Rick Knowland, Senior Planner  
**CITY OF PORTLAND**  
389 Congress Street  
Portland, Maine 04104

Enclosed are our initial responses and related information to comments received to date regarding the preliminary site plan application for the proposed renovation of the Cumberland County Civic Center. Please let me know if you would like a hardcopy of attached information as well. We look forward to discussing this project with the Planning Board on June 5<sup>th</sup>. Please let me know if you have any questions or additional comments. Thank you.

**Preliminary staff review comments on the Cumberland County Civic Center site plan submitted on May 11, 2012 received to date prepared by Rick Knowland (attached).**

SHEET TITLE:	375700-SP101.DWG
WBRC CAD FILE:	375700
PROJECT NO.:	375700
SCALE:	1"=20'
PROJECT MANAGER:	MEJ
DRAWN BY:	JWB
CHECKED BY:	ARB
SHEET NO.:	CP101

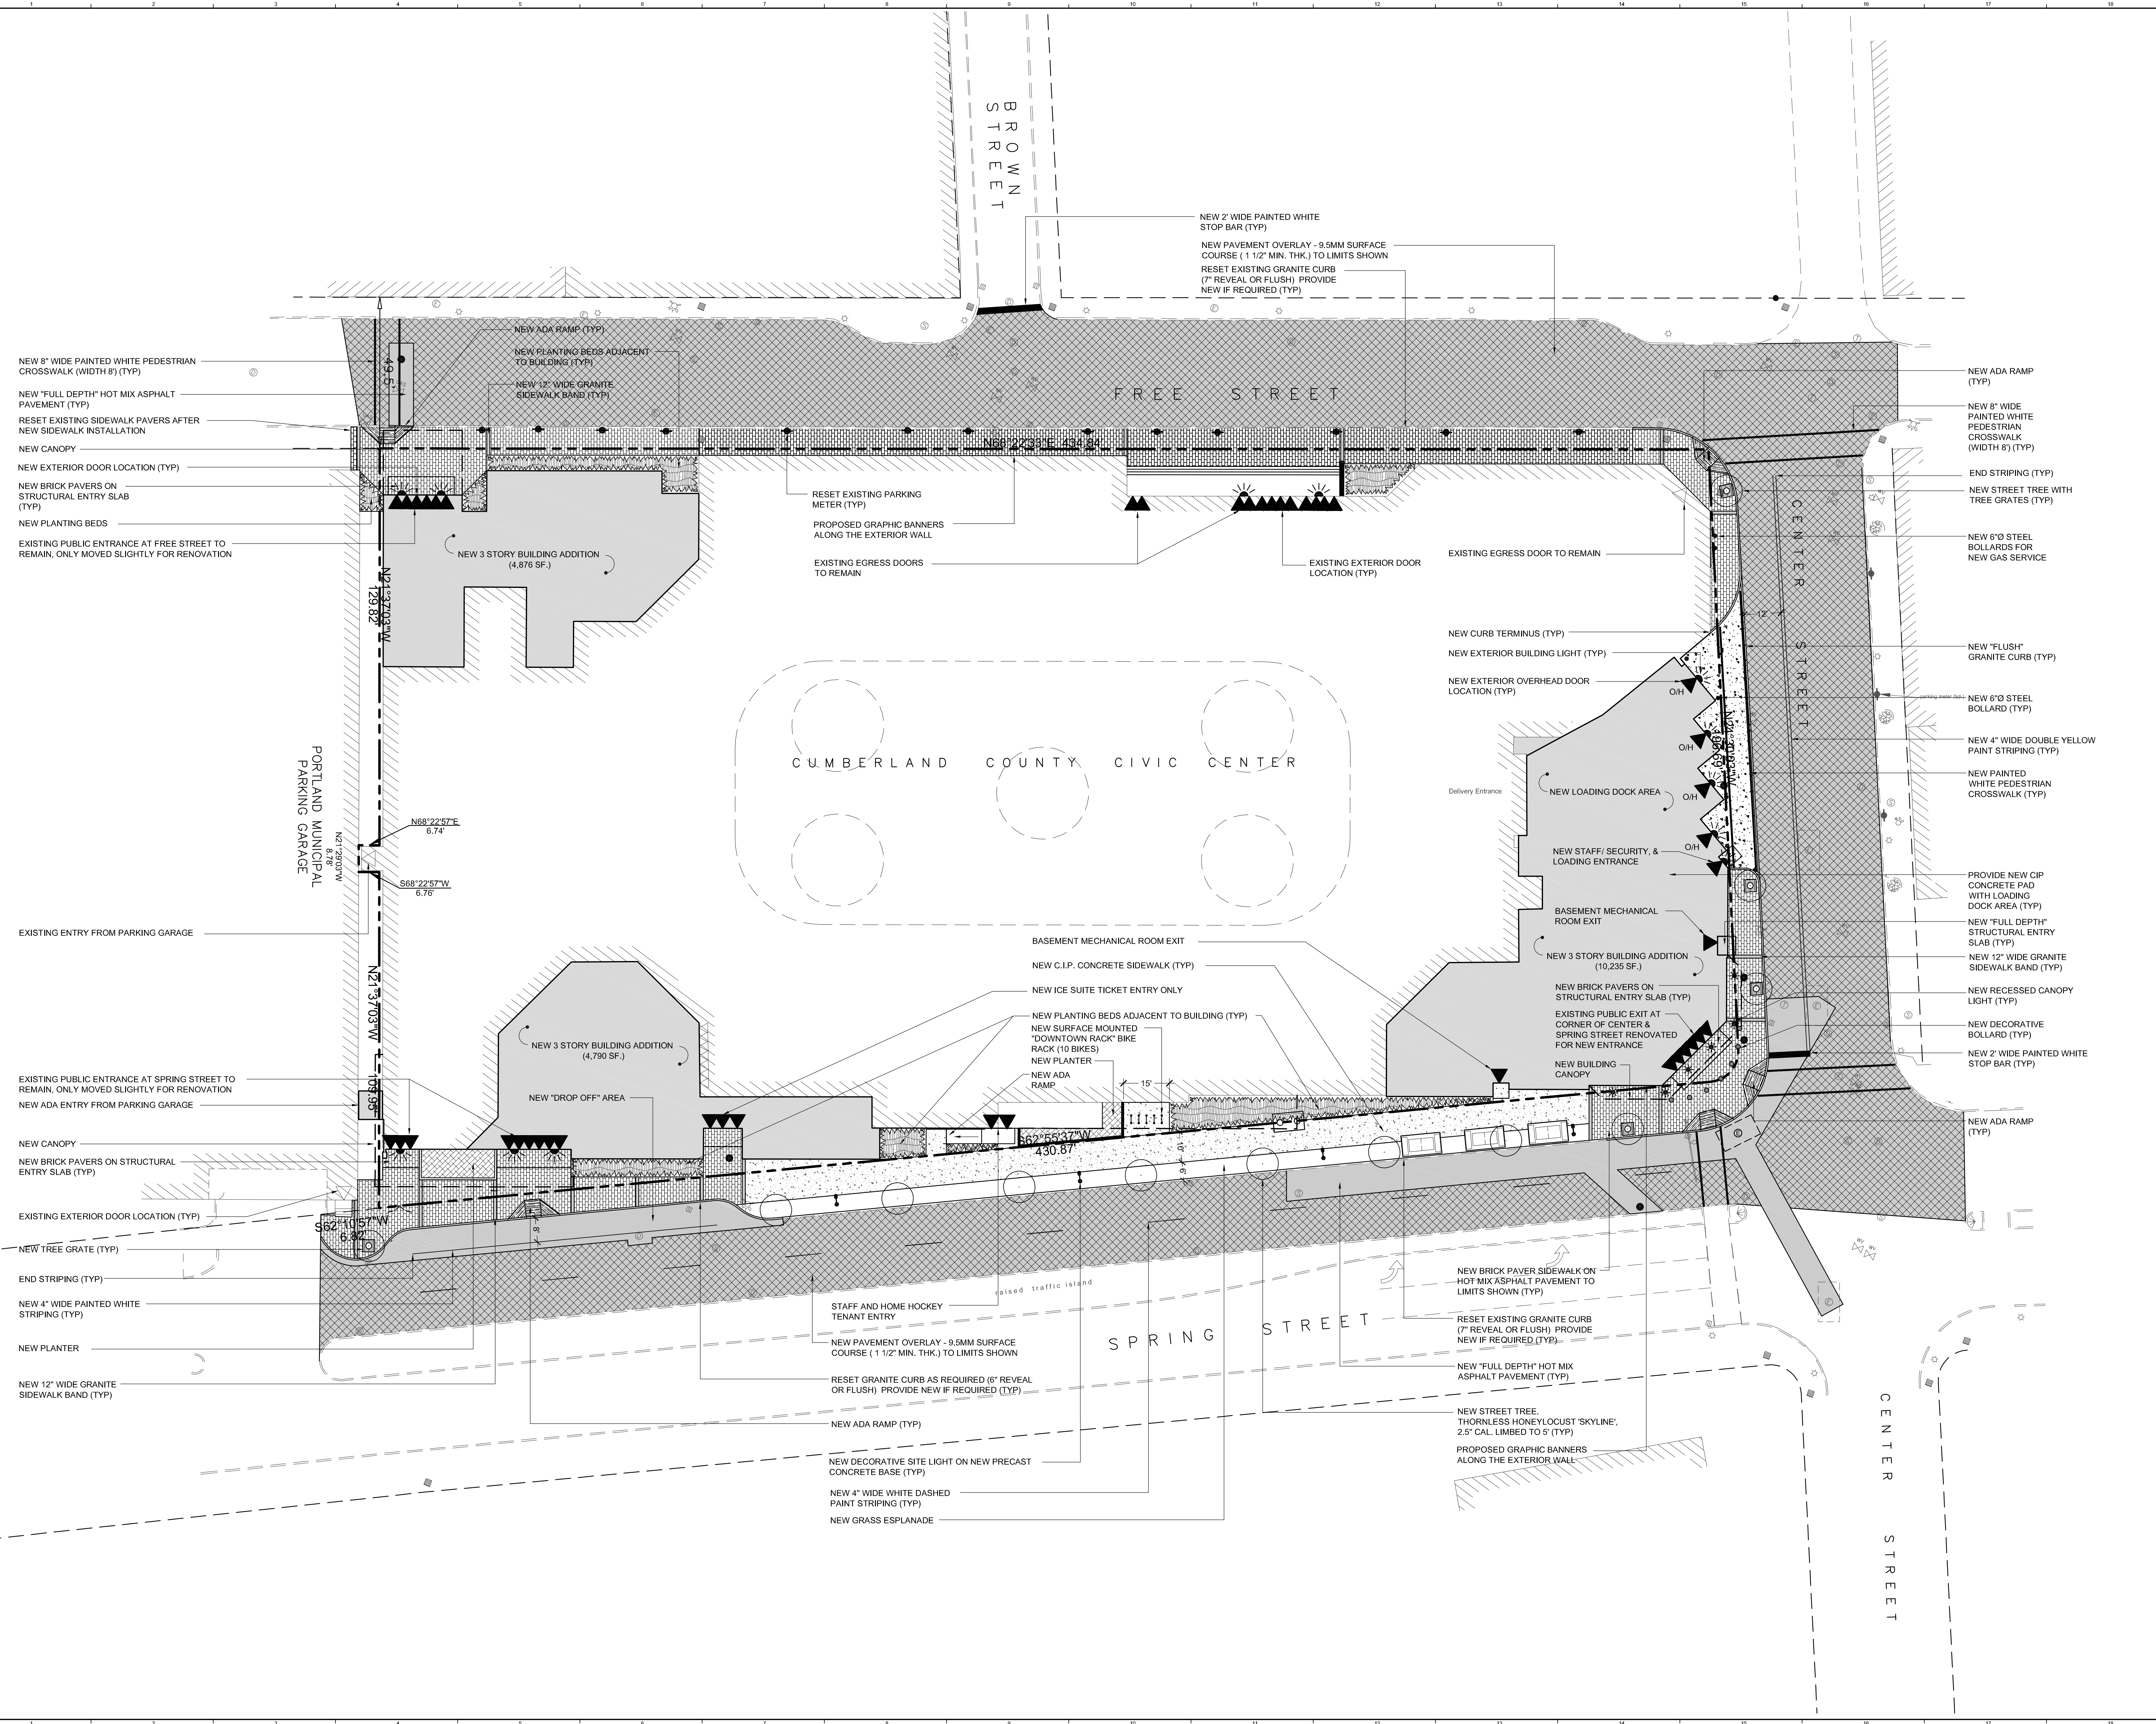
3. I'm assuming that the black triangles represent entrances. Could you clearly indicate which entrances are public entrances? Also I'm assuming some entrances are limited to exiting so if that is the case please label accordingly. Other entrances may be non-public which is ok but we need to know which ones are used by the public so we can understand pedestrian circulation issues. ***See labels for exterior entrances on revised sheet CP101 – Site Layout Plan.***

6. On sheet CP101 it appears the existing grass esplanade along Spring Street is not labeled. Please clarify accordingly. Also near the Spring/Center entrance, along Spring St. adjacent to the

building is an unlabeled triangular area. Is it grass, concrete or some other material? **Grass esplanade has been labeled. Unlabeled triangular area will be concrete. See revised sheet CP101 – Site Layout Plan for more information.**

7. The sidewalk along Spring St. is shown as 8 feet wide however given the volume of civic center pedestrians a wider sidewalk of a min. 10 feet is appropriate. **The referenced sidewalk width has been increased to 10'. See revised sheet CP101 – Site Layout Plan for more information.**

9. Do you need that many bollards in front of Spring/Center entrance? Also are handicap ramp users being crowded by the bollards directly adjacent to the handicap ramp? **The bollards are intended to protect the building entrance from possible vehicle impacts. The bollard layout has been revised to provide additional access adjacent to the handicap ramp. See revised sheet CP101 – Site Layout Plan for more information.**

25. The City standard for crosswalks at signalized or controlled intersections is parallel lines. The crosswalks at the Spring Street/Center Street intersection should reflect this standard. ***Pavement markings have been revised (see CP101 – Site Layout Plan).***

31. The applicant should provide details on the Center Street typical section between Free Street and Spring Street. Based upon the plans provided, changes to pavement markings are being proposed. Details on travel and parking lane widths should be provided as well as what approach lane configurations are proposed at each abutting intersection. I would also note that a recommendation in the Congress Street Bus Priority Study was to reverse the direction of Center Street between Congress Street and Free Street, and lane configurations should be compatible with this change. ***See revised sheet CP101 – Site Layout Plan.***

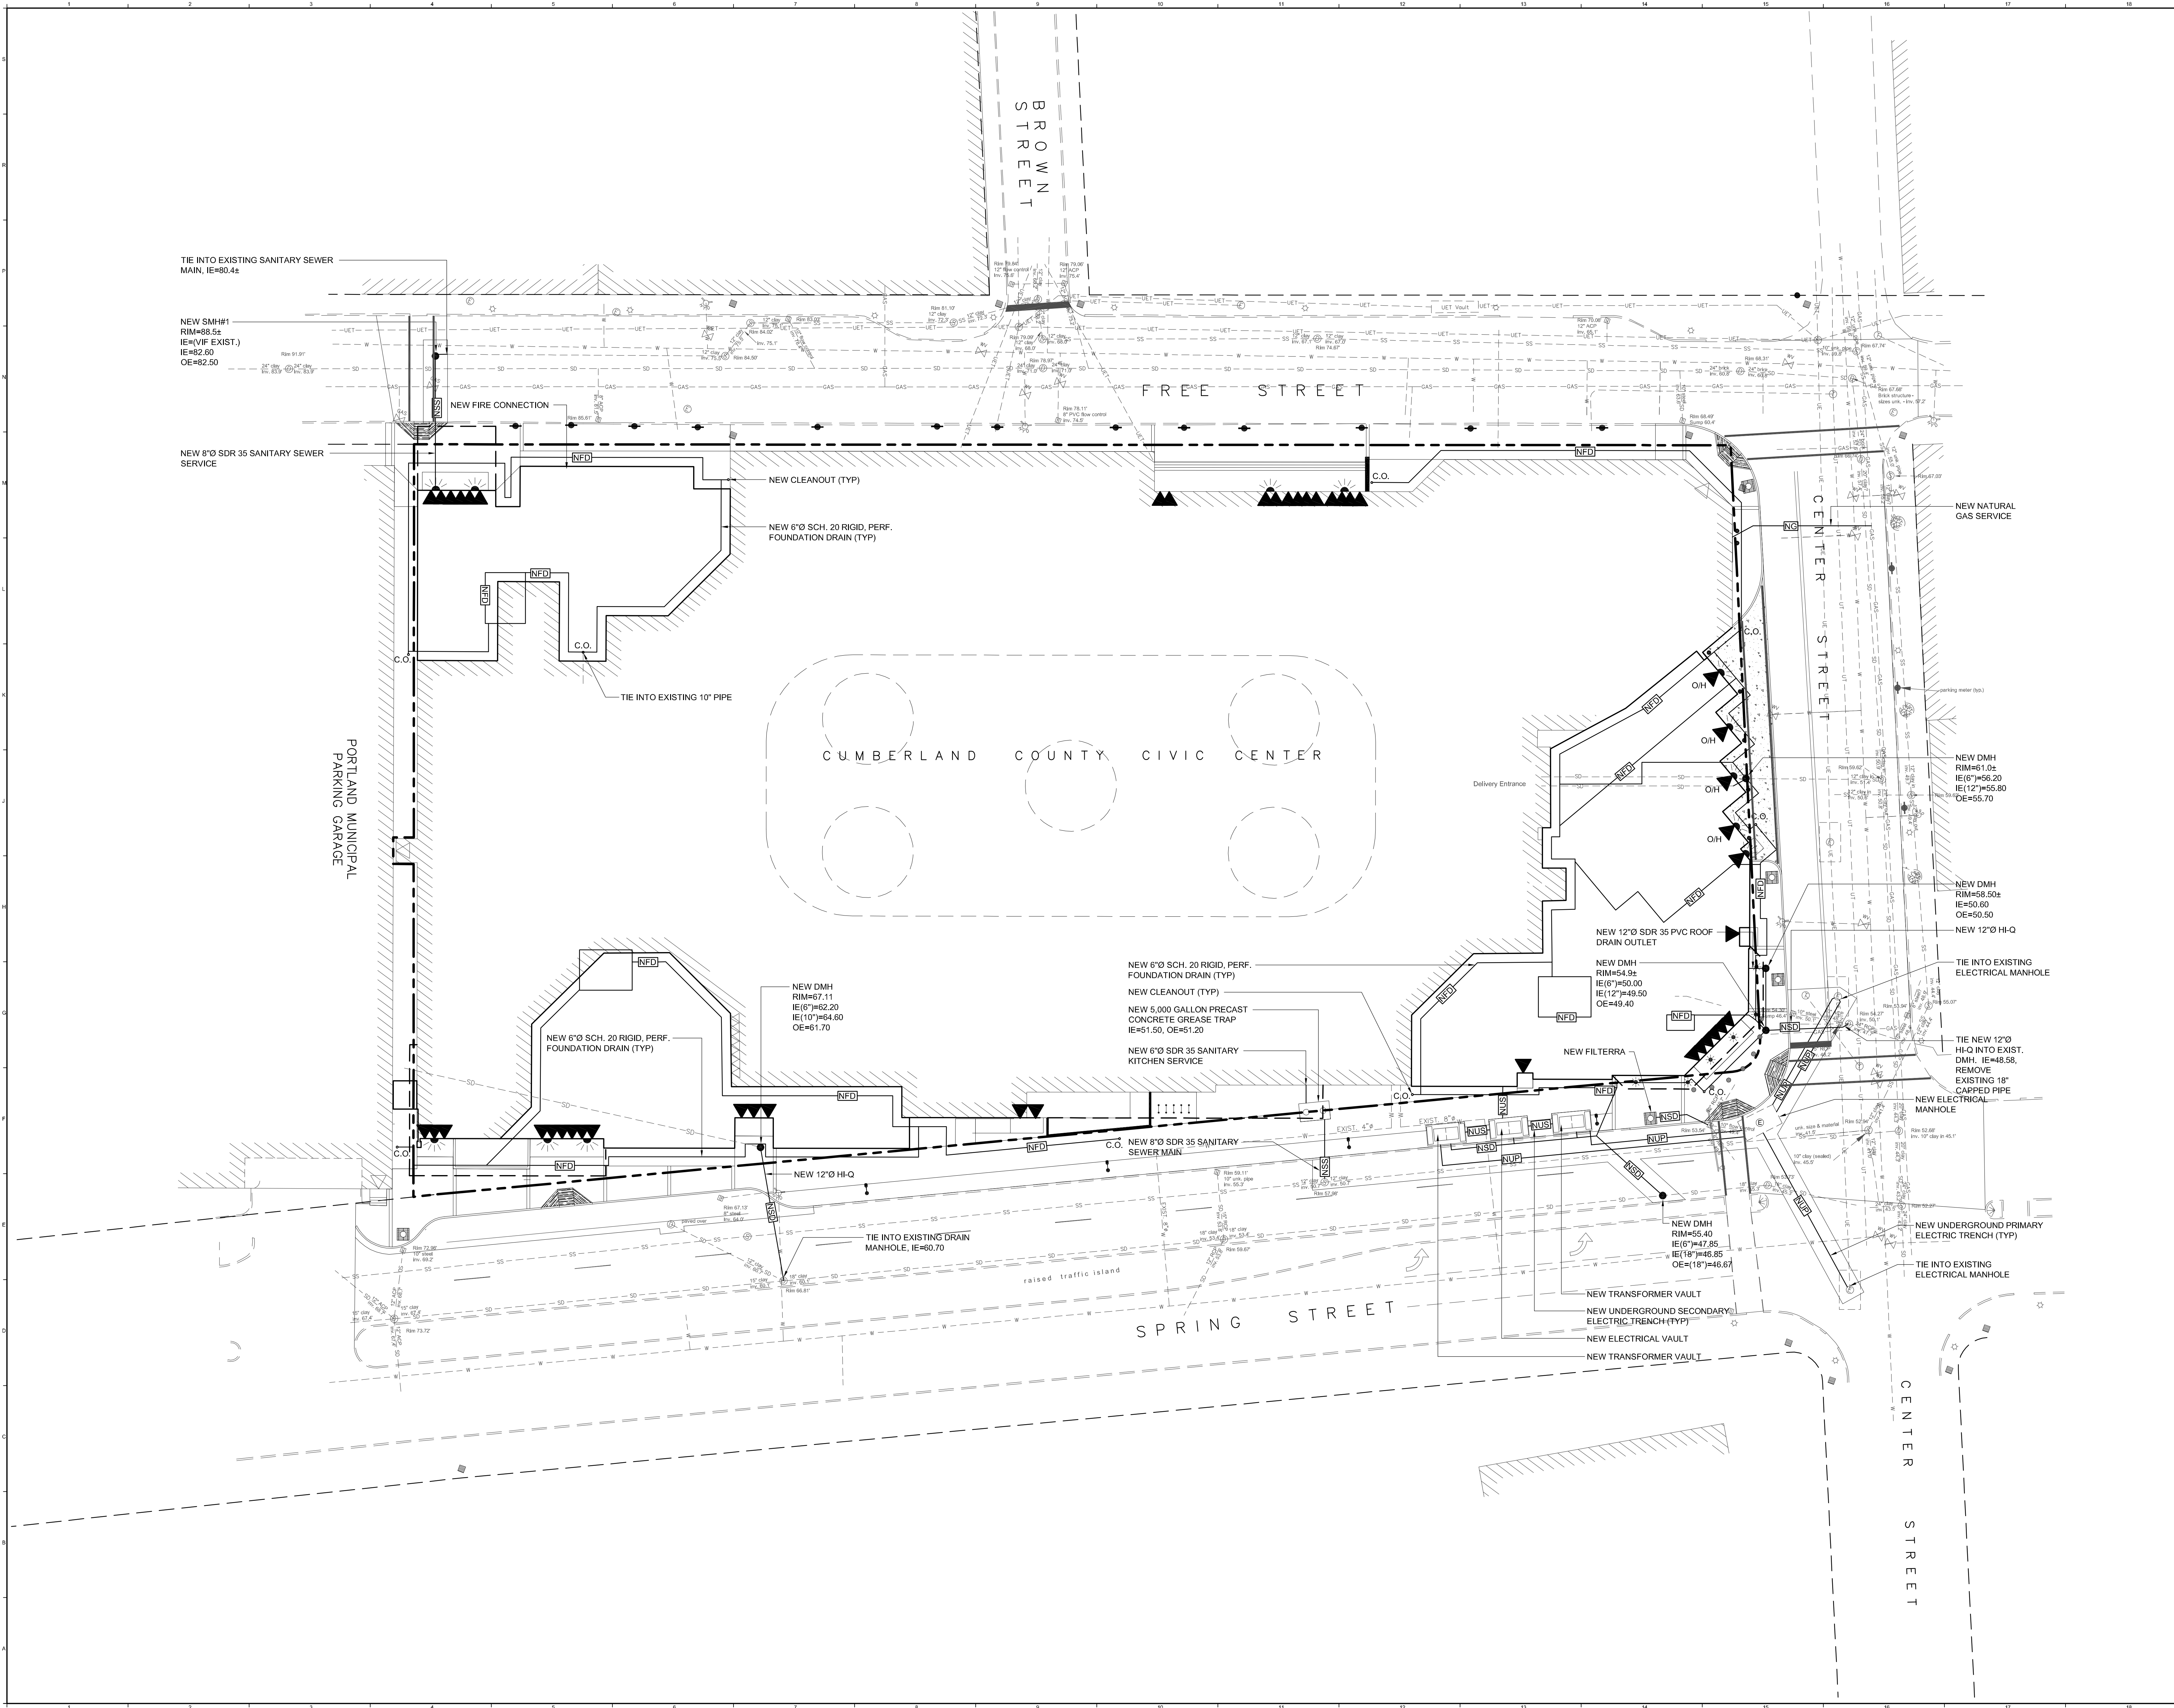
10. On sheet CU101, please clearly indicate where the water service comes into the building. Are the new sewer lines replacing existing lines? Wasn't sure if the plan indicated location of existing lines. Letters from Portland Water District and City of Portland regarding utility capacity are needed. **Water service and sewer service is indicated on revised sheet CU101 – Site Utility Plan. We have contacted the Portland Water District for a capacity letter for water and wastewater treatment and the City of Portland Public Services for a sewer capacity letter. Initial discussions with the District and the City of Portland indicate adequate capacity is available for this project. Capacity letters will be submitted with the final site plan application submission.**

19. All proposed connections to catch basins have been eliminated. Two (2) new sanitary service connections are proposed, one (1) on Free Street to accommodate a new toilet room and one

(1) on Spring Street to accommodate a new commissary kitchen service with exterior grease trap. A new sewer manhole is proposed on Free Street because no existing sanitary services are located in the vicinity. The grease trap service connection is shown tying into existing manhole MH-5177 on Spring Street, but will tie into the existing service line if possible. See revised sheet CU101 – Site Utility Plan for more information.
